RFI

RFI #: 11
 Date: 12/14/2011
 Job: EB-02 Keller Springs Lofts
 Phone: 877-777-5115

Subject: Detail for 15" leave out

Subject: Purposed relocation of oil separator

4 TYPICAL GRADE BEAM PENETRATION DETAIL
S3.04 NO SCALE

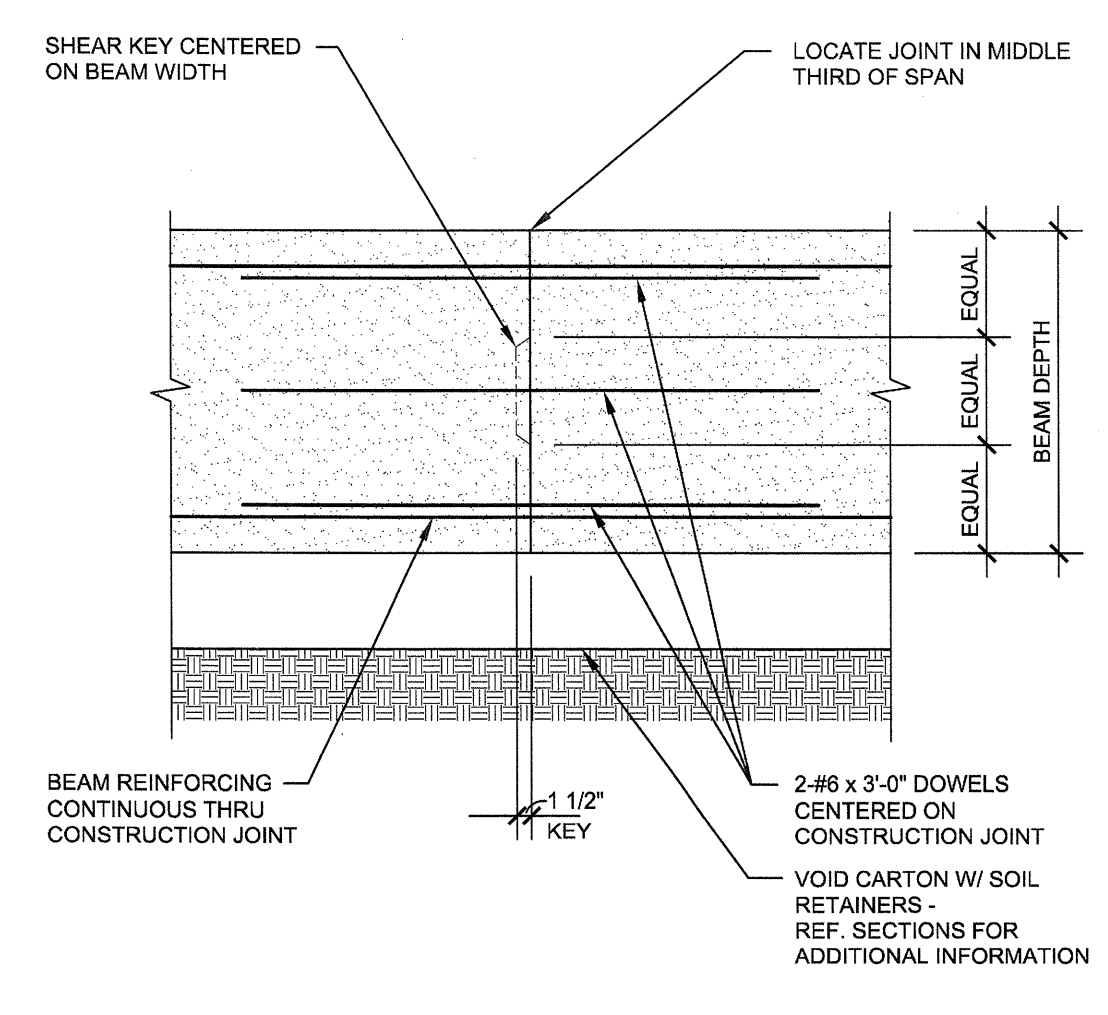
Request: Trent we need a detail for (2) 12" drain sleeves that penetrate the southern beam wall of the garage Ref P 3.0D attached.
 The structural engineer wants sleeves in the middle third of the beam wall. Top of Beam Wall = 639'-7 1/4" and beam is 4' deep 635' 7 1/4". Middle of the beam = 637' 7 1/4" - 6" (12 x 12") = 637'-1 1/4". So the bottom of the two 12" sleeves should be at 637'-1 1/4" or 637'-10. This should give us plenty of fall as the original flow line of the 12" on CS was 636'-22" just inside the building. Ref CS. Can both PPO and Jordan & Skala concur and reflect it on their plans and detail?

Please see attached for a grade beam penetration detail that will accommodate the above mentioned 12 inch diameter penetrations. If the center line of either of the penetrations is closer than 2'-0" to grid line B, notify PPO for an alternate solution.
